November 13, 2017

Re: Del Webb @ Mirehaven Arroyo LOMR Request  
Comment Response Letter  
Hydrology File No. H09D017D

REVISED TO REFLECT LOMR  
EFFECTIVE: December 17, 2018

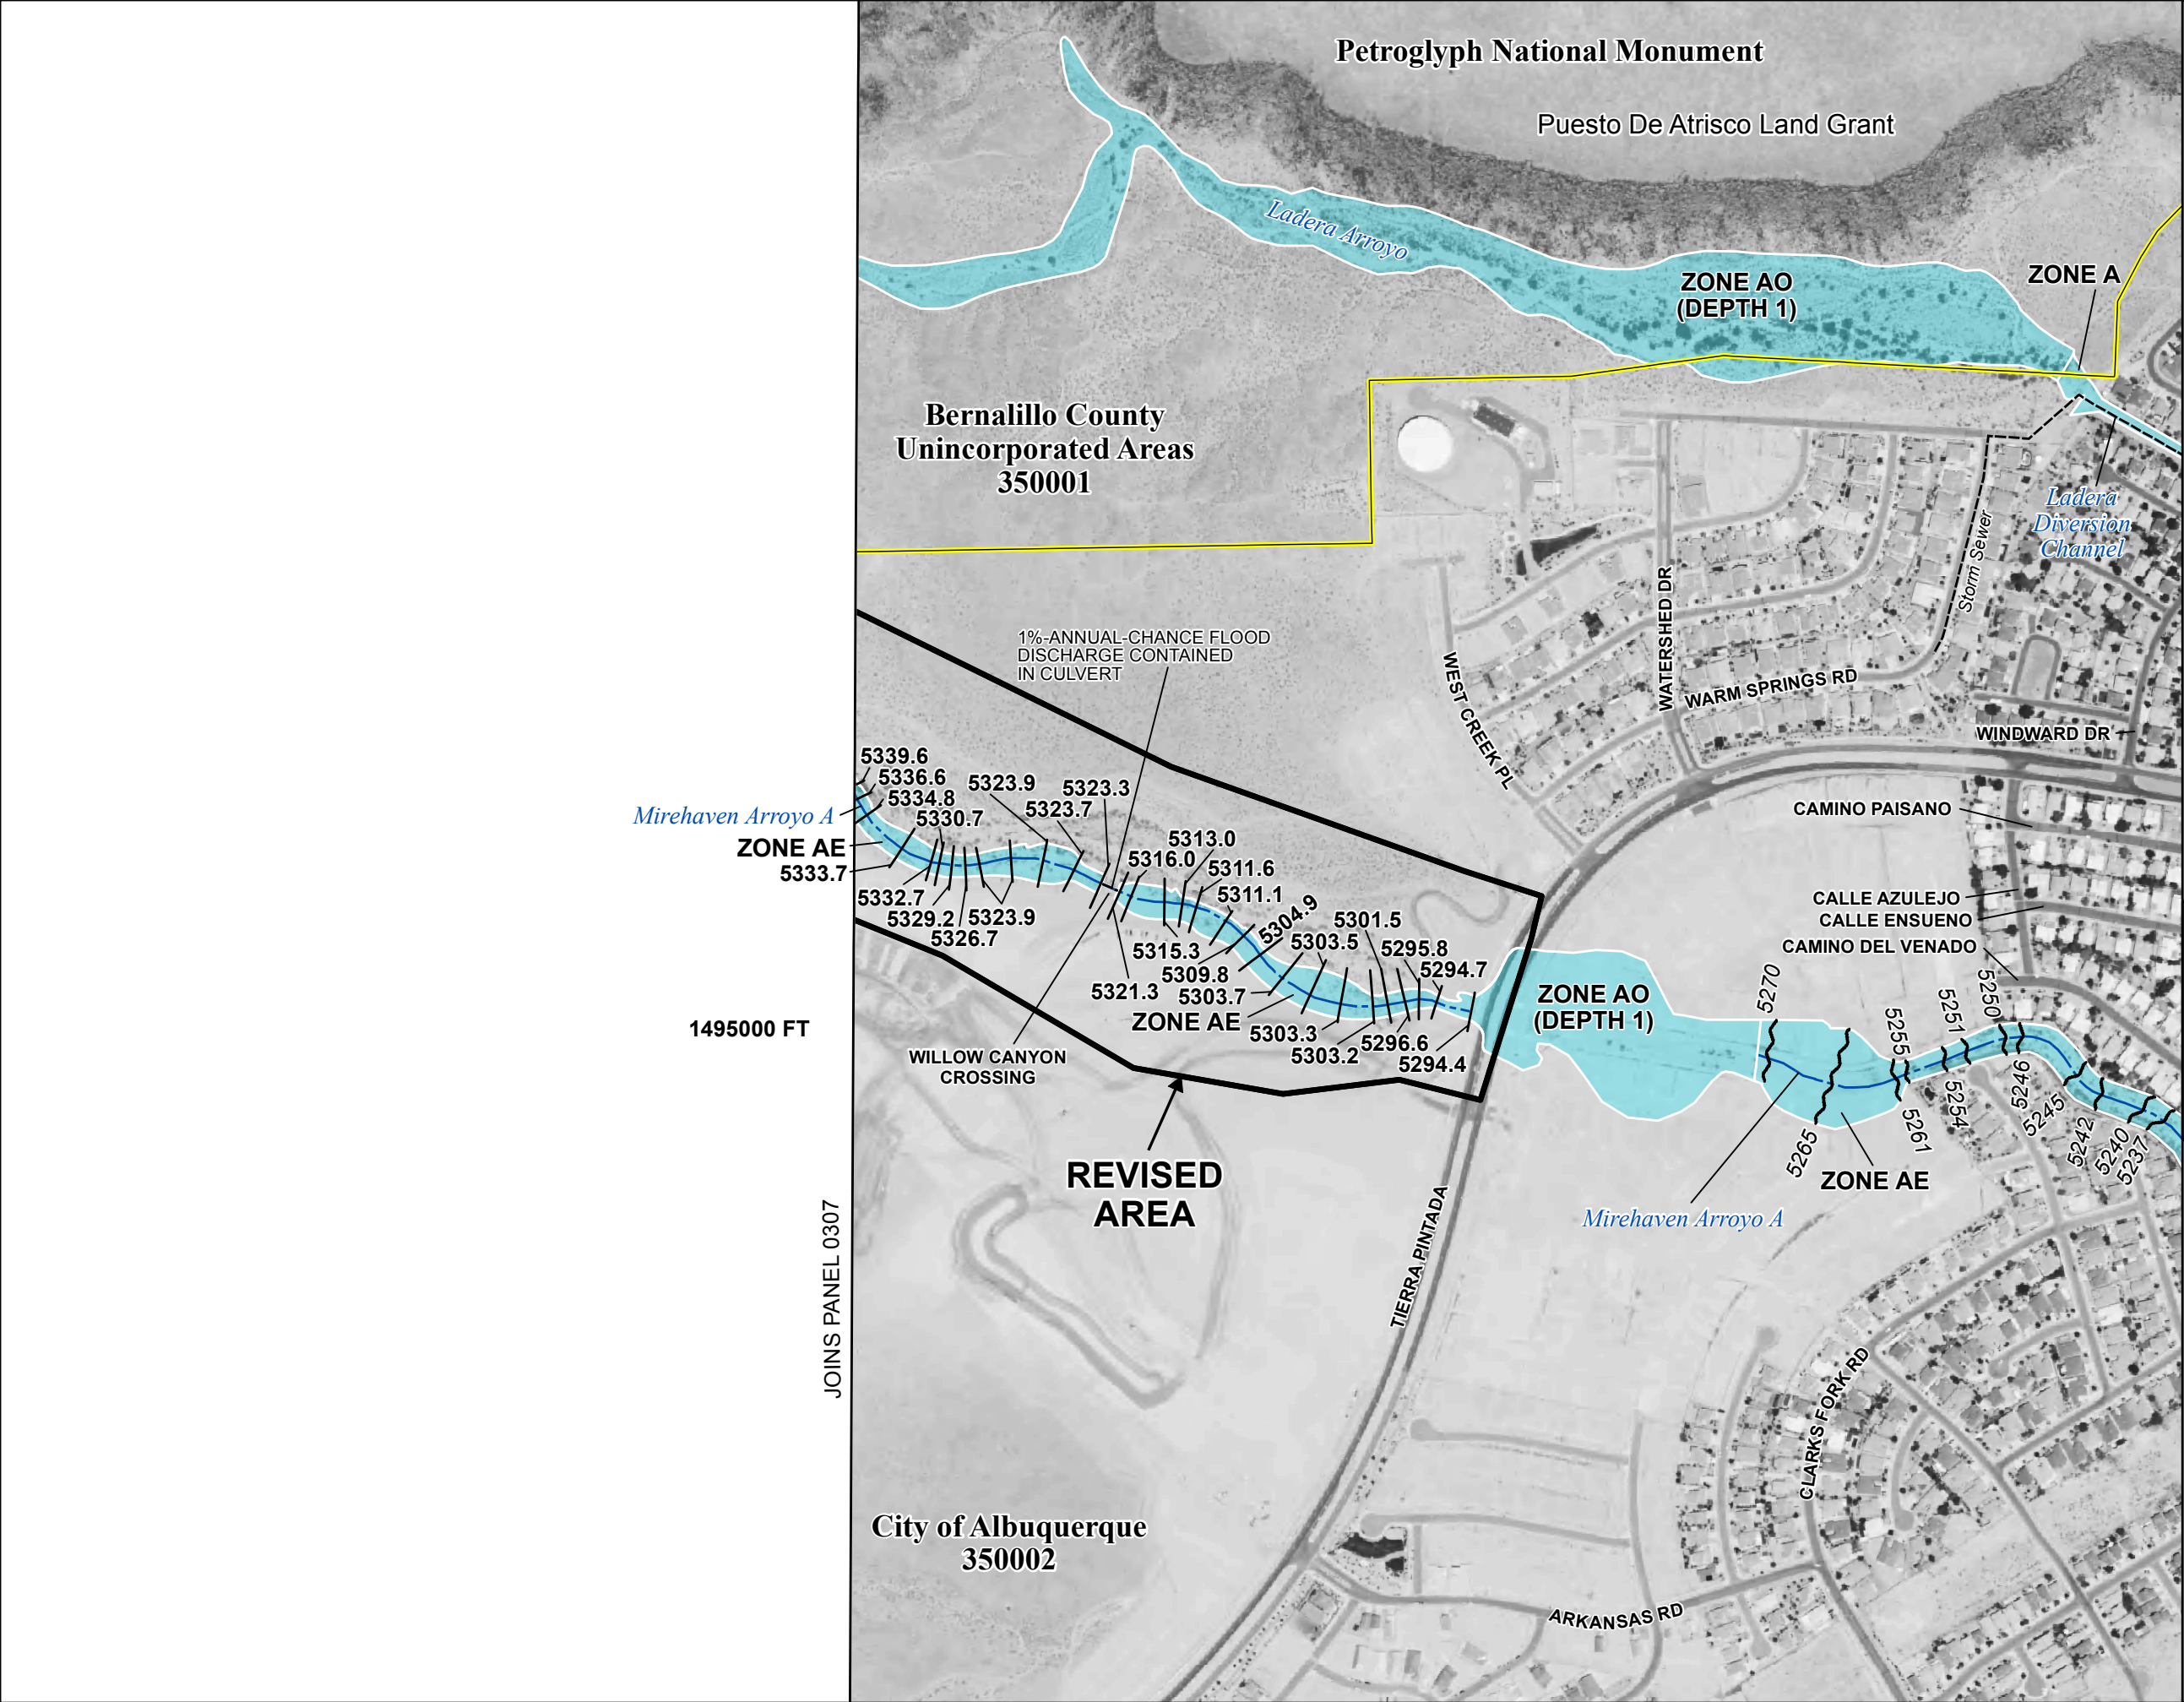
10. The annotated FIRM needs more specific labels added. The portion of the revised floodplain that is contained by the shotcrete bank protection should be changed from an AO zone to an AE zone with BFE contours labeled near the top and toe of each grade control structure. The portion upstream of the shotcrete should still be mapped as an AO zone due to its erosive shifting nature.

- *Response: As requested, the proposed revised reaches upstream of the shotcrete bank protection have been labeled as Zone AO. The reach contained by the shotcrete is labeled as Zone AE. As discussed at our October 16, 2017, meeting, it is my experience that FEMA produces their own BFE labels for the revised FIRM that accompanies the LOMR and that the Annotated FIRM does not require BFE labels. As the engineer of record, it is our preference to not provide BFEs on the Annotated FIRM to limit the potential for this data to be misinterpreted by others in the future. Our opinion is that the HEC-RAS model and more detailed Topographic Work Map or the official FIRM issued by FEMA should be consulted to determine BFEs. BFE labels were not added to the Annotated FIRM.*

FLOOD PROFILES

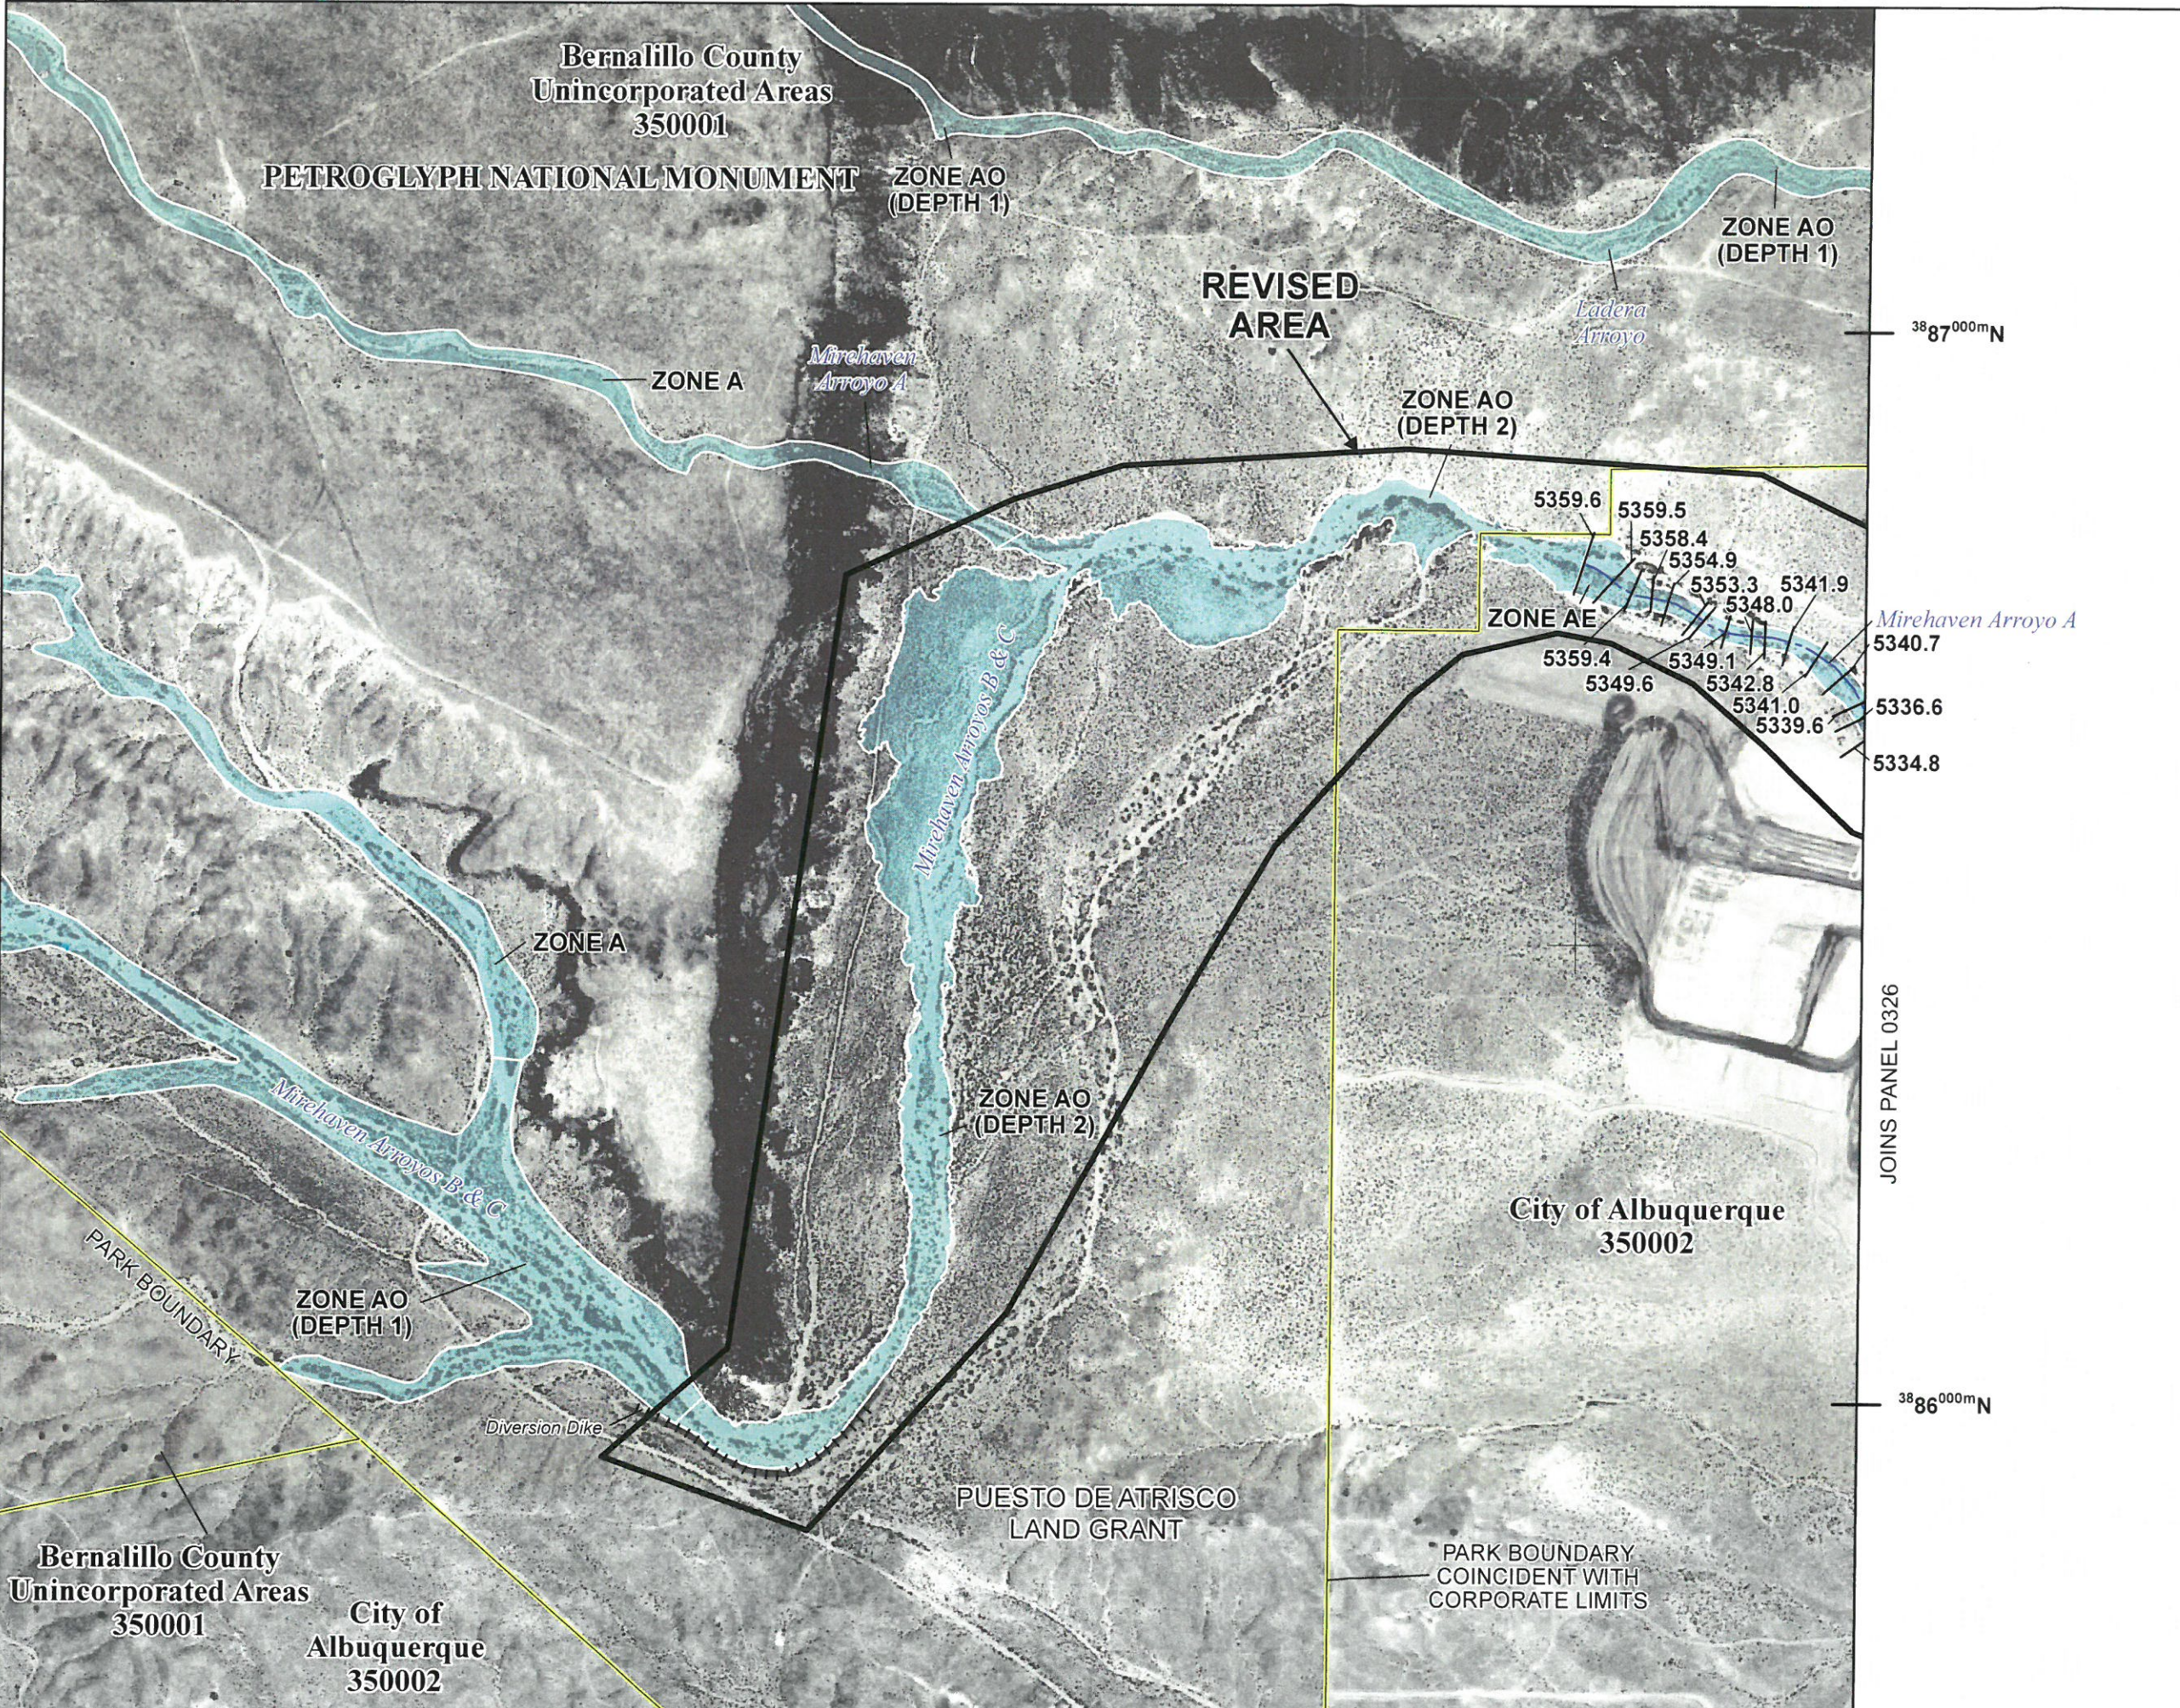
11. The BFE should be based on subcritical depth. Please revise the HEC-RAS model and all profiles and exhibit to reflect the subcritical elevations. There are too many abrupt changes in channel geometry to assume that any portion of the flow is supercritical.

- *Response: As requested, only the subcritical model has been submitted and subcritical water surface elevations are reflected on exhibits.*
12. Additional comments may be made after the city is given the opportunity to review the missing and revised information listed above.
